From: Martyn White <Martyn.White@arun.gov.uk> **On Behalf Of** Conservation Officer
Sent: 22 July 2026 13:46
To: Planning.Responses <Planning.Responses@arun.gov.uk>
Cc: Jonny Cooper <Jonny.Cooper@arun.gov.uk>
Subject: EP/55/26/HH

EP/55/26/HH

Address: Vista Point 21 Tamarisk Way East Preston BN16 2TE

Proposal: Replacement of first floor rear glazing.

DRAWING
EXISTING AND PROPOSED GLAZING
ELEMENT W.3

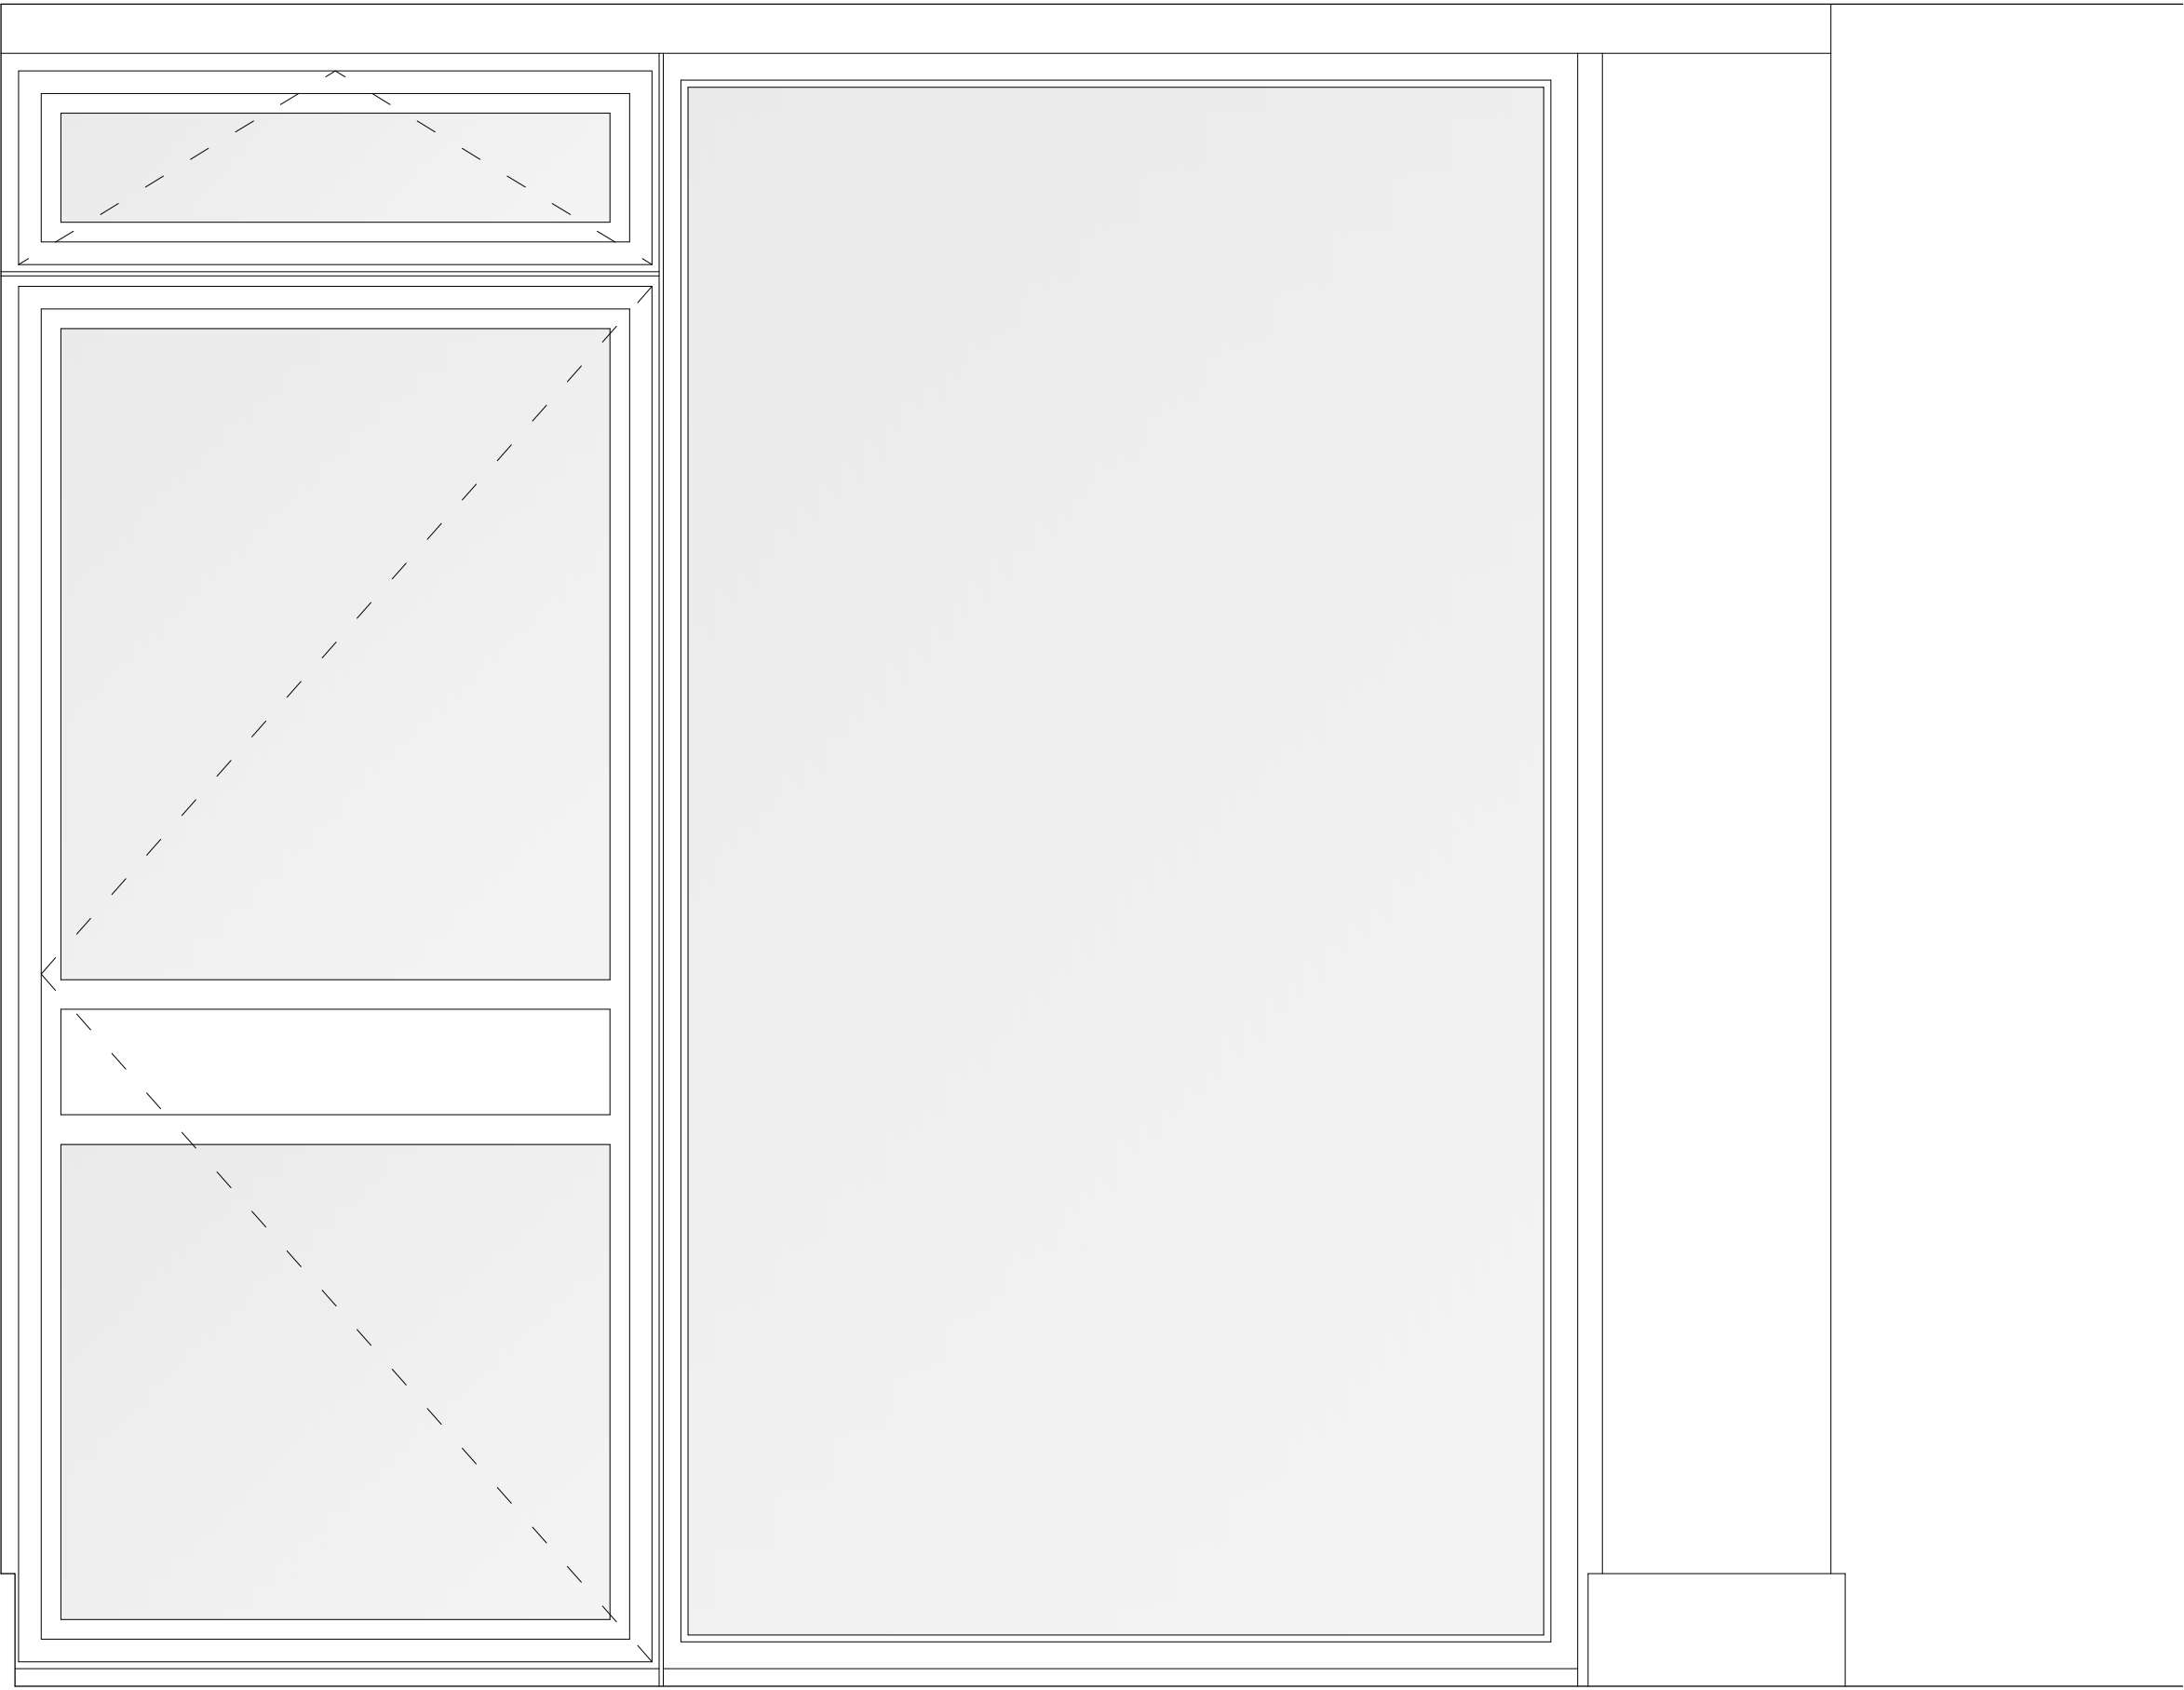
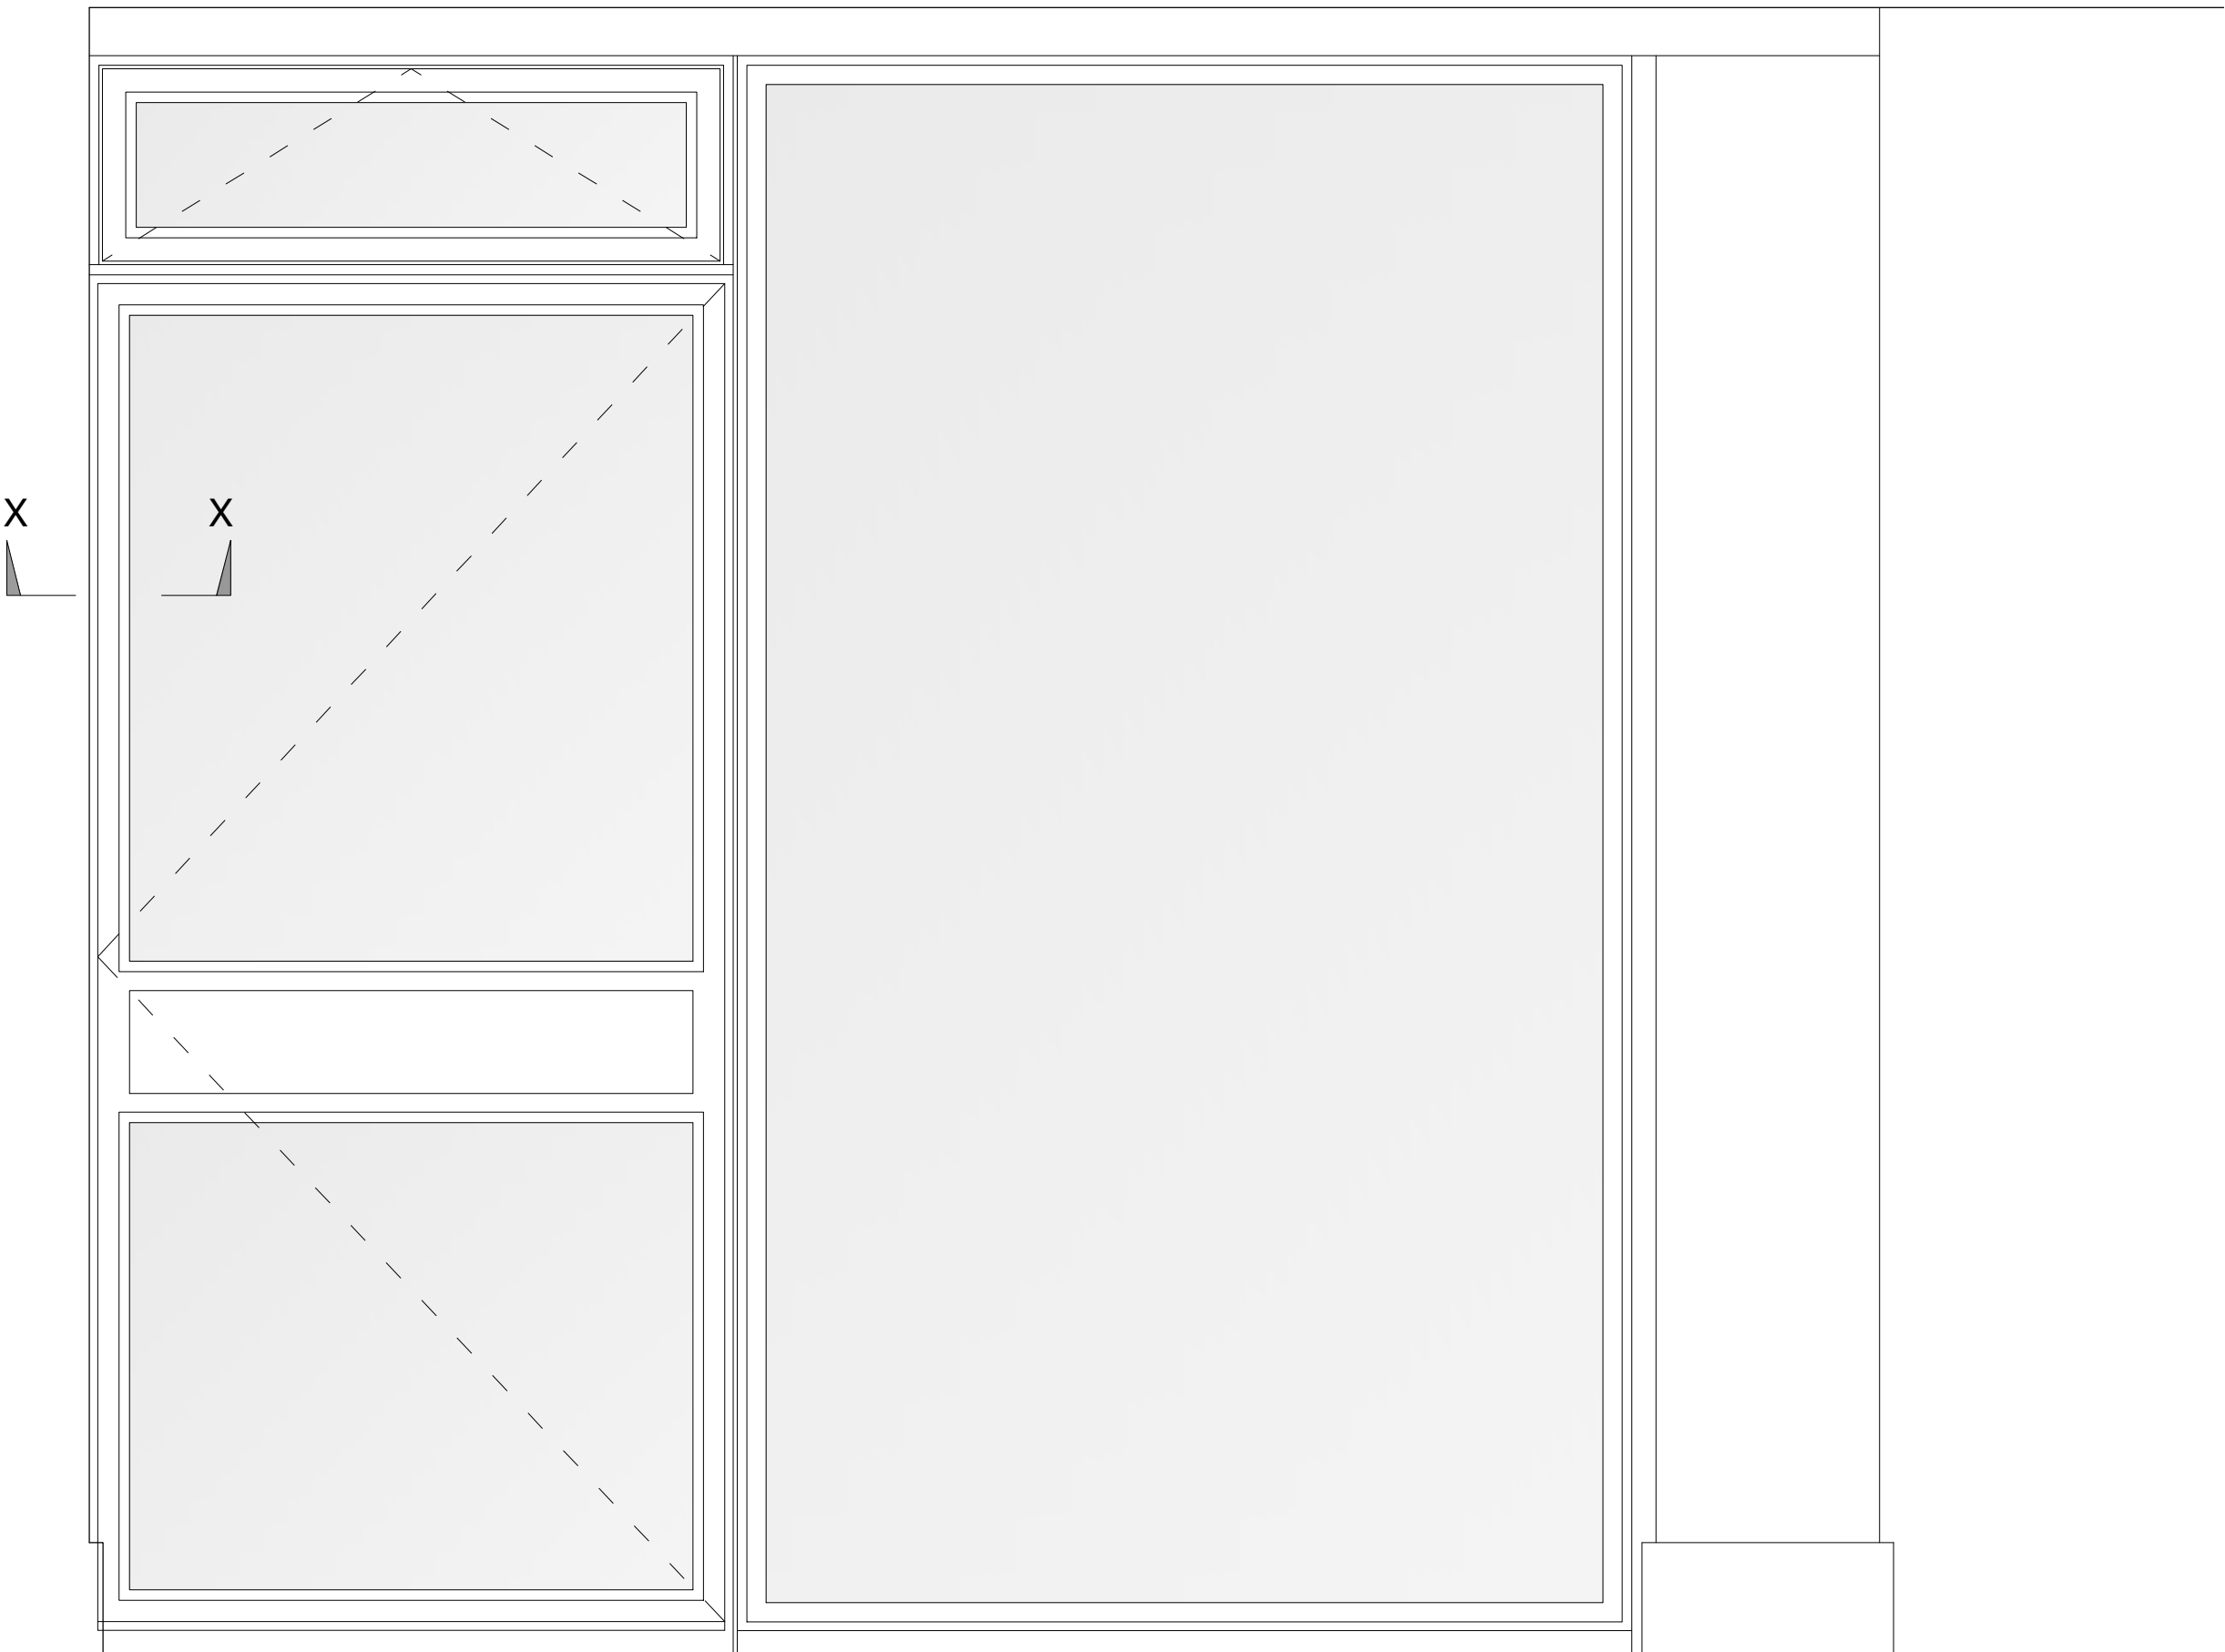
The general approach to the replacement of the windows is positive. However, I have one concern. Whilst the proposed arrangements for windows W3 and W5 seek to replicate the existing design, they do not appear to accurately reproduce the existing glazing proportions. In particular, the vertical frame sections associated with the fanlight and the casement below do not appear to be of a consistent width when compared with the existing arrangement, resulting in a subtle alteration to the sightlines and visual balance of the glazed openings. As the proposed arrangement for W2 appears to more closely replicate the existing sightlines, the applicant should clarify whether the framing sections to W3 and W5 can be adjusted to more closely reflect the existing arrangement.

Further clarification is required regarding the details of the two windows before I can conclude a level of harm.
